From: Tim Rodway | Rodway Planning [REDACTED]
Sent: 12 July 2019 15:25
To: Maria Tomalova; Nicola Spencer
Subject: RE: FP/274/18/PL, 10 Felpham Gardens

ARUN DISTRICT COUNCIL FP/274/18/PL

PROPOSED ELEVATIONS
UNIT 1

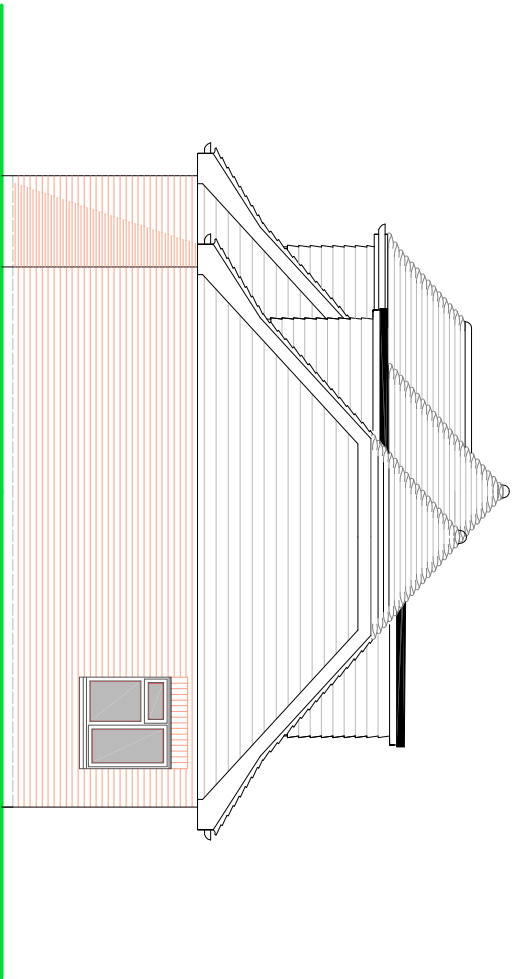
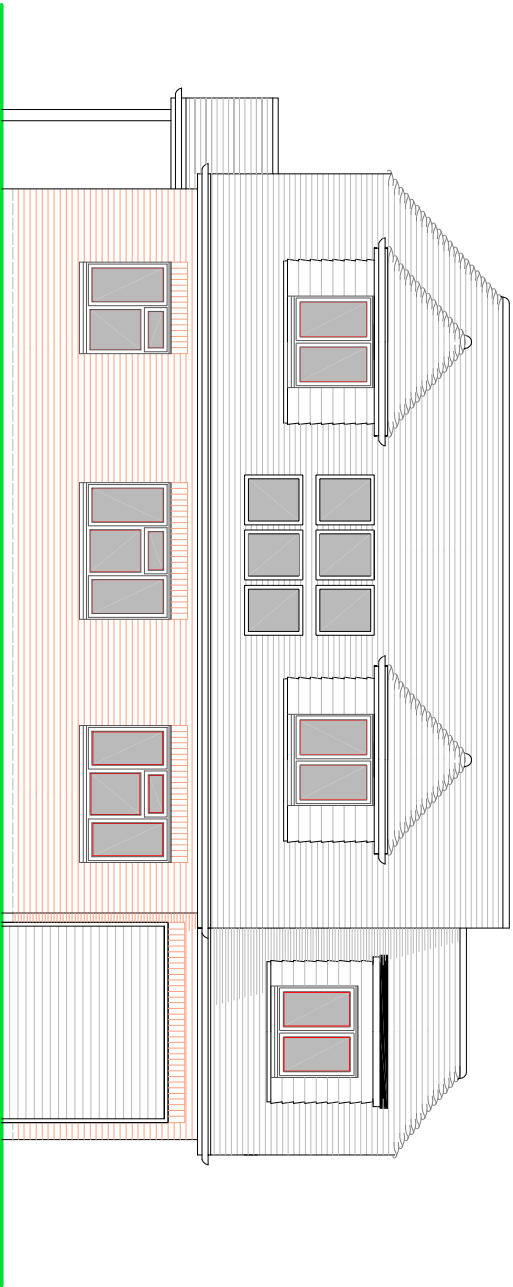
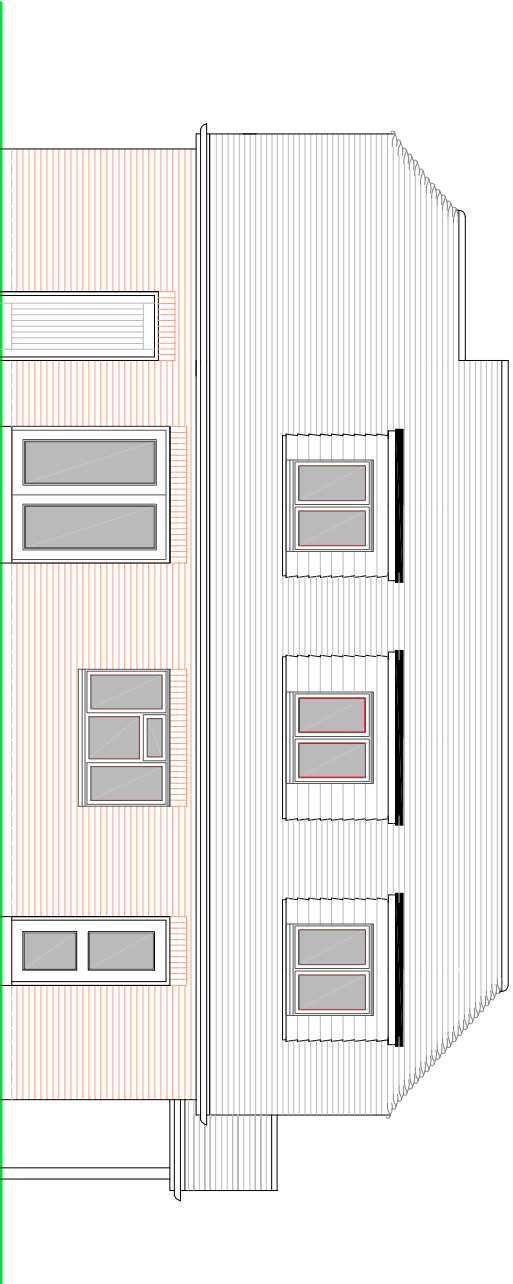
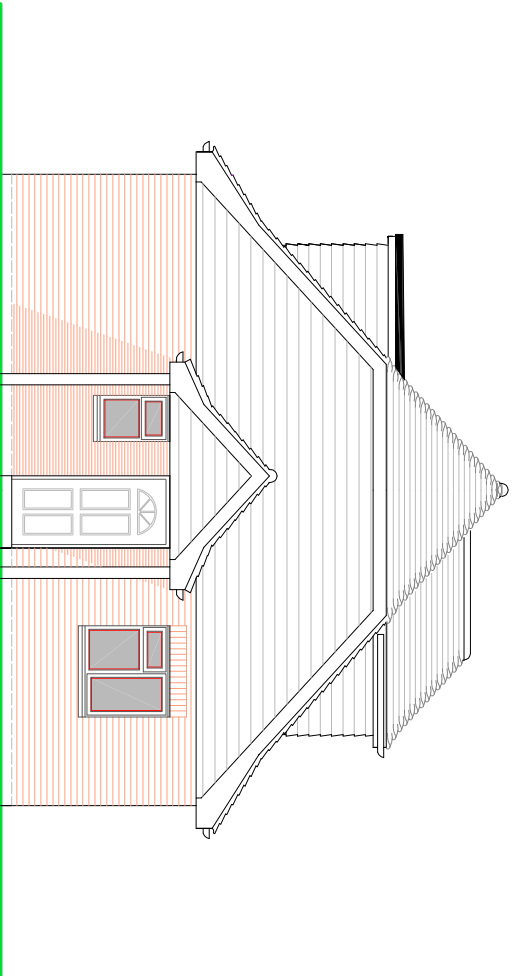
In the submitted drawings of Unit 1 , Northern Elevation the dormers window are shown openable and with a clear glass.

I would advise you to amend this drawings showing the windows of the proposed dormers non openable up to 1.7m and obscure glazed to avoid confusion.

PROPOSED ELEVATIONS
UNIT 2

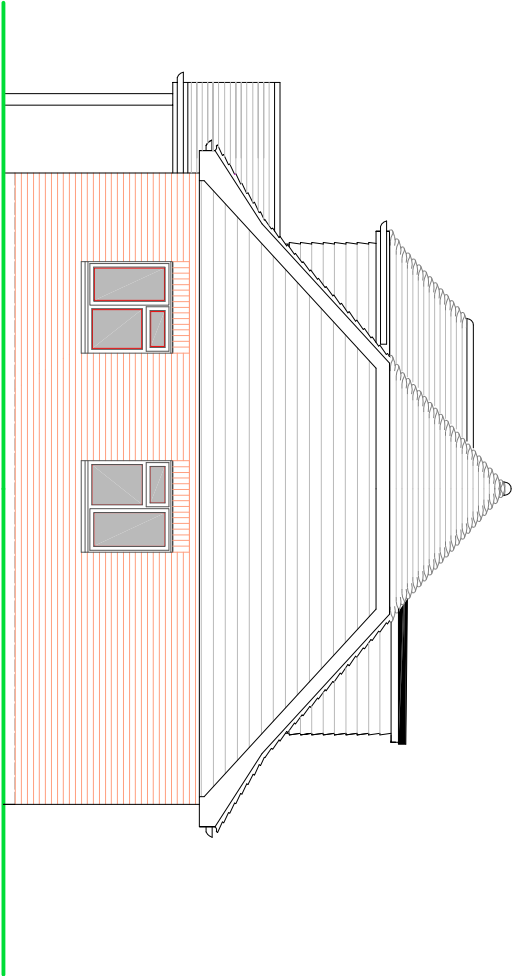
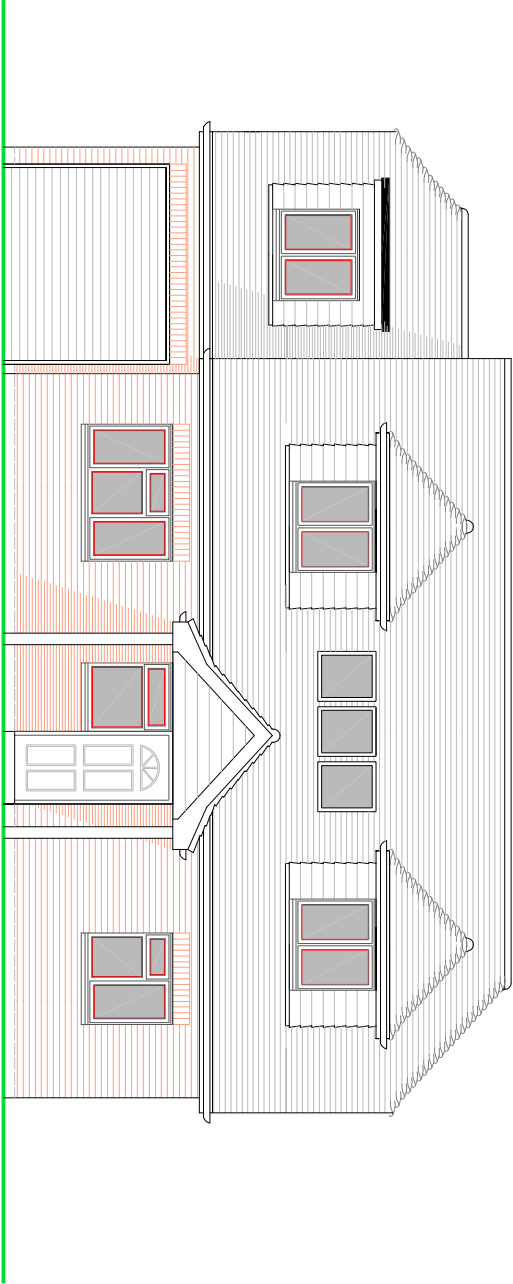
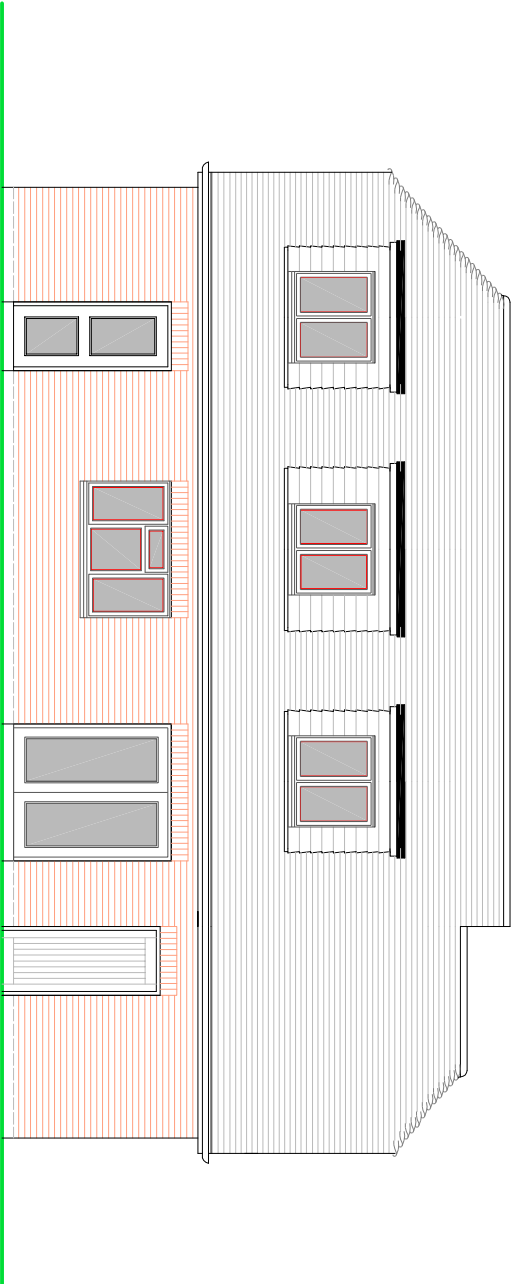
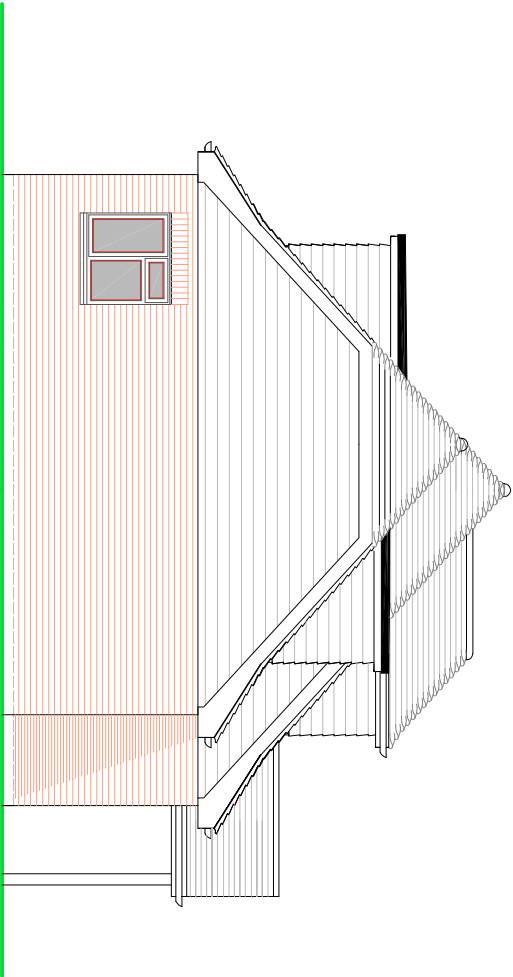
- Unit 1 is proposed aligned with the existing house No 8 Felpham Gardens as such it would not affect substantially the residential amenity of this property.
- However the proposed Unit 2 of the same shape and scale as Unit 1 would be obscuring the outlook from the rear of No 8 and would be an overbearing structure (12.5m deep, 6.7m high), entirely closing the view to the south and within the winter time when the sun is low, from the sun-light.
Suggestion: proposed Unit 2 should be reduced considerably (the height in the between of the proposed Unit 1 and an existing bungalows to the east) to be acceptable without affecting the amenity and prospect of inhabitants of No8
Probably you can reduce the width of Unit 2 by re-positioning the garage where the cycle storage is proposed with a direct access to it.
